Our Ref: BR/196/18/A

**Town & Country Planning (Control of Advertisement) (England) Regulations 2007 (as amended)
Application for Advertisement Consent**

Development Various illuminated & non-illuminated advertisements on various elevations.
Location The Co-op 152-156 Hawthorn Road Bognor Regis

001-088-103

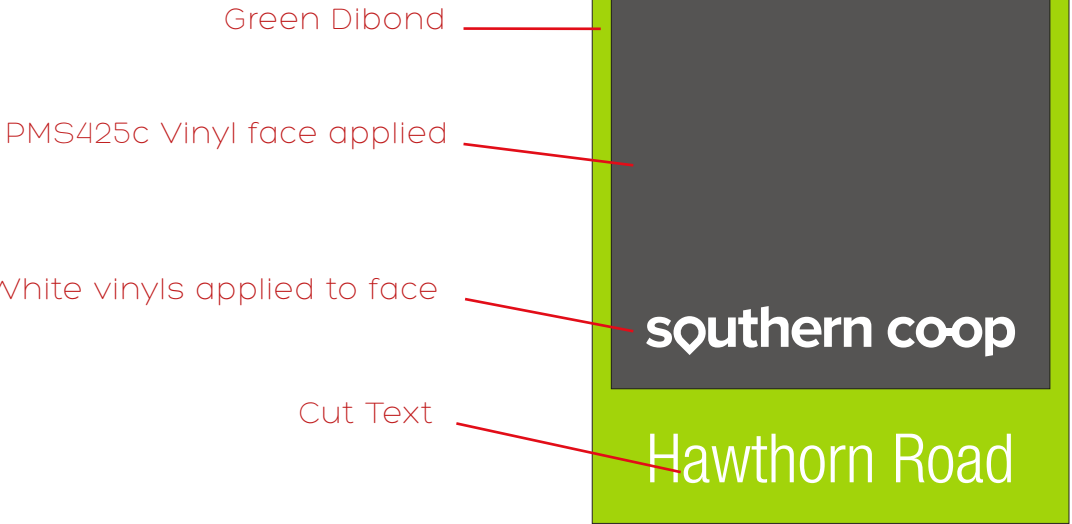
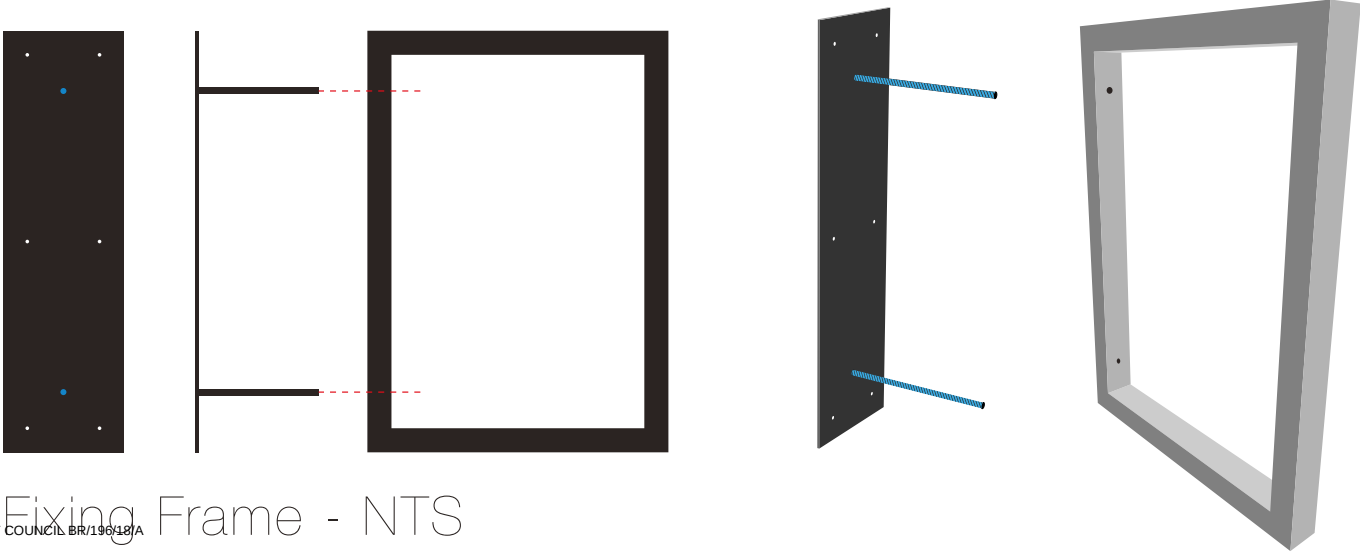
Please indicate if Fascia sign 2 is internally or externally illuminated.
